## KITTITAS COUNTY COMMUNITY DEVELOPMENT SERVICES

**RE: Jones Variance (VA-25-00004) – Project Paused Pending Further Documentation**  
Parcel #520234

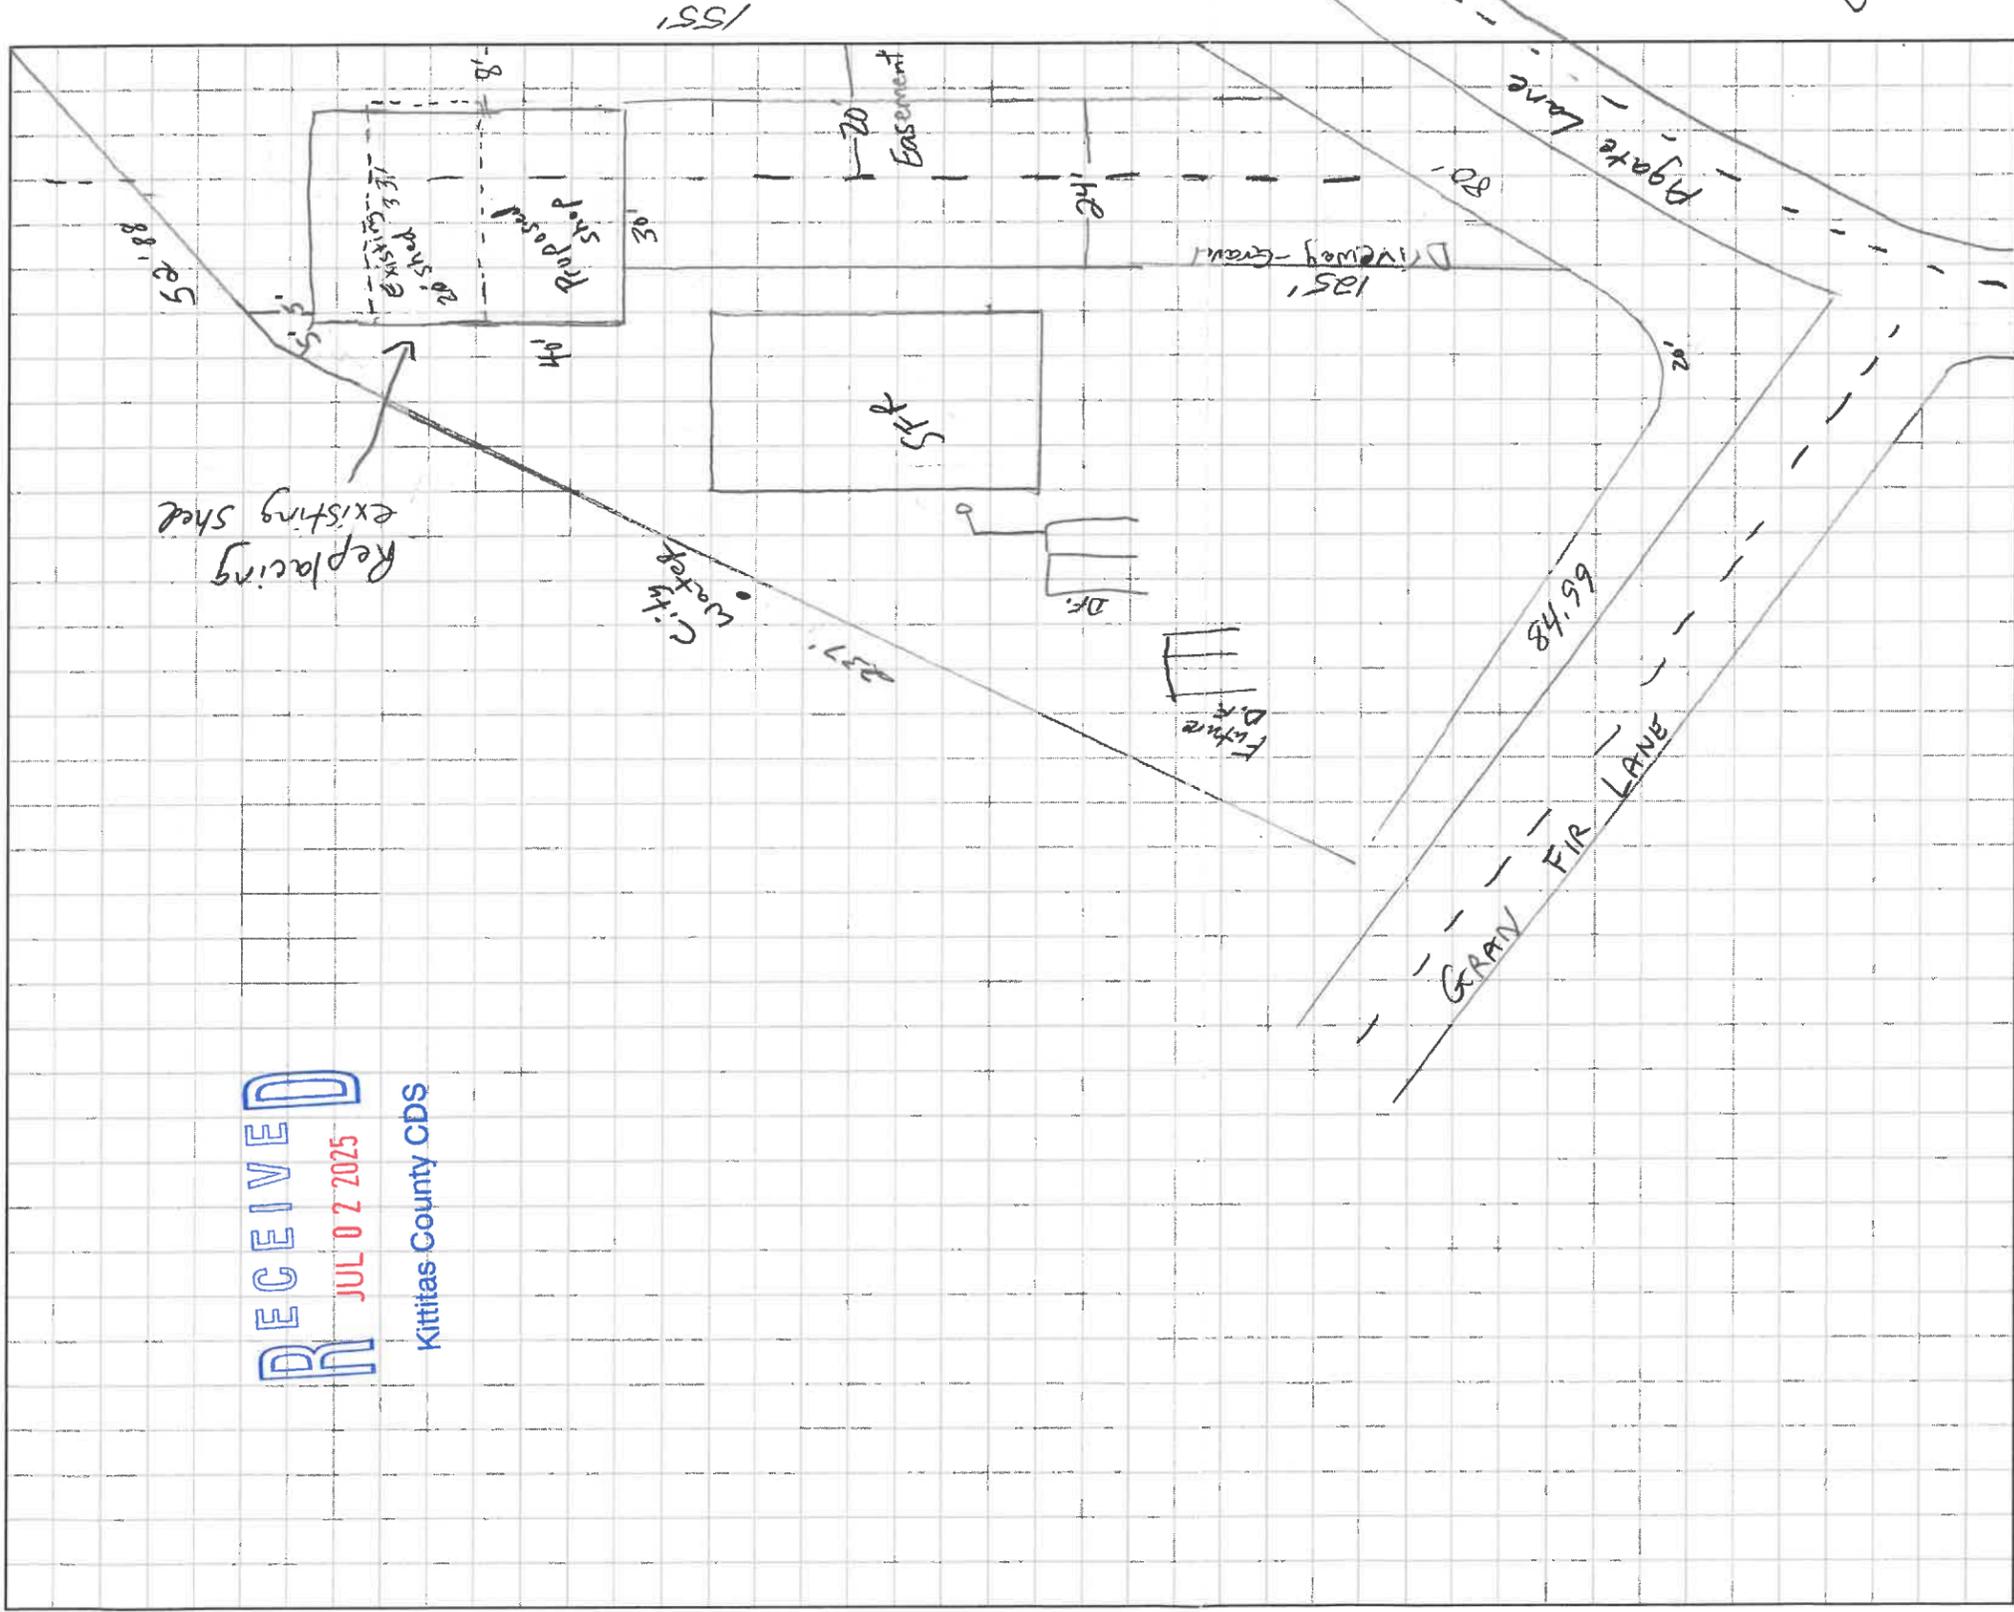
2. Documentation of Easement Vacation:
  - a. In accordance with comments received from Kittitas County Public Works, *"The proposed shop expansion falls on an existing 20' wide easement (per Survey 201806200044). The easement shall need to be vacated prior to approval, unless the purpose of the easement specifically would not be impacted by a building OR unless specifically approved by the Building Official."*

- i. In order to adhere to this requirement, the applicant shall need to contact a Title Company to vacate the aforementioned easement. Resulting documentation of this process will then need to be recorded with the Kittitas County Auditor's Office. This is a required action that must be completed prior to finalization of this project.
